CASA Ref: F24/3132-90

NOTICE OF EXHIBITION - WASTE MANAGEMENT FACILITY, 2-4 HALE STREET, BOTANY (SSD-62855708): CASA COMMENTS

CASA has reviewed the Aviation Impact Assessment (AIA), by Arup of March 2024, for the Proposed Waste Management Facility at 2-4 Hale Street, Botany.

Figure 6: Overlay of site location on Sydney Airport OLS Chart³ (Dated 05/02/21)

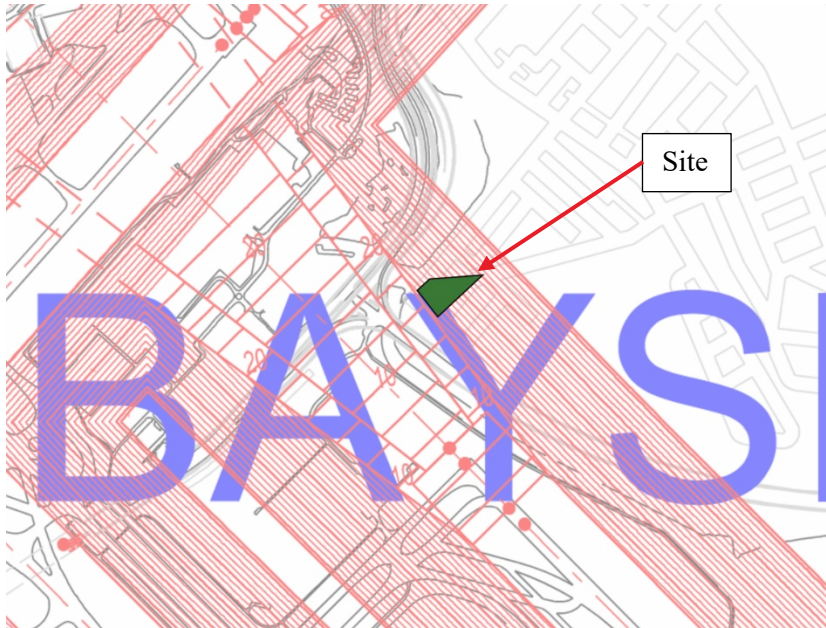
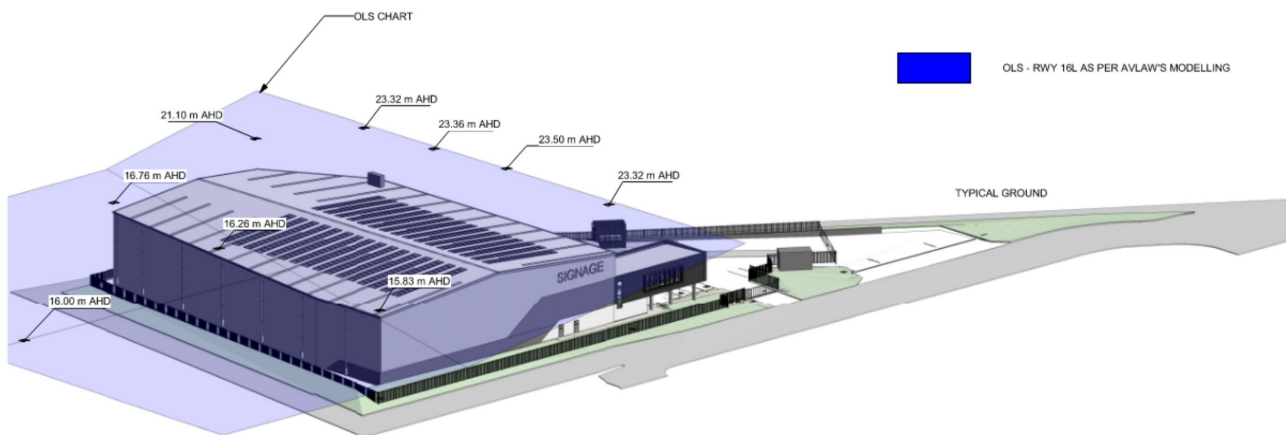
Further to section 4.5 (which advises that the cranes will be coordinated at a later date ... as expected); following are incidental comments about cranes:

In accordance with the Airports (Protection of Airspace) Regulations 1996 (the Airspace Regulations), cranes that infringe an Obstacle Limitation Surface will require a controlled activity approval from the Federal Department of Infrastructure, Transport, Regional Development, Communications and the Arts (DITRDC). At the appropriate stage, the proponent should seek a controlled activity approval through Sydney Airport (AirspaceProtection@syd.com.au). Sydney Airport will confirm the infringement and obtain comments from aviation stakeholders including CASA and Airservices Australia and refer the application to DITRDC. (Sometimes, DITRDC will request a Construction (Crane) Management Plan in advance to verify the feasibility of building the project within limitations).

From Figure 4 of the Protected Airspace Review, it appears that there may be crane proposals that could infringe the Transitional Surface. Each case will be assessed on its merits at the time. Conventional construction methods and/or scheduling may not be viable. For example, some lifts may need to be performed by mobile cranes that would operate during Airport curfew.
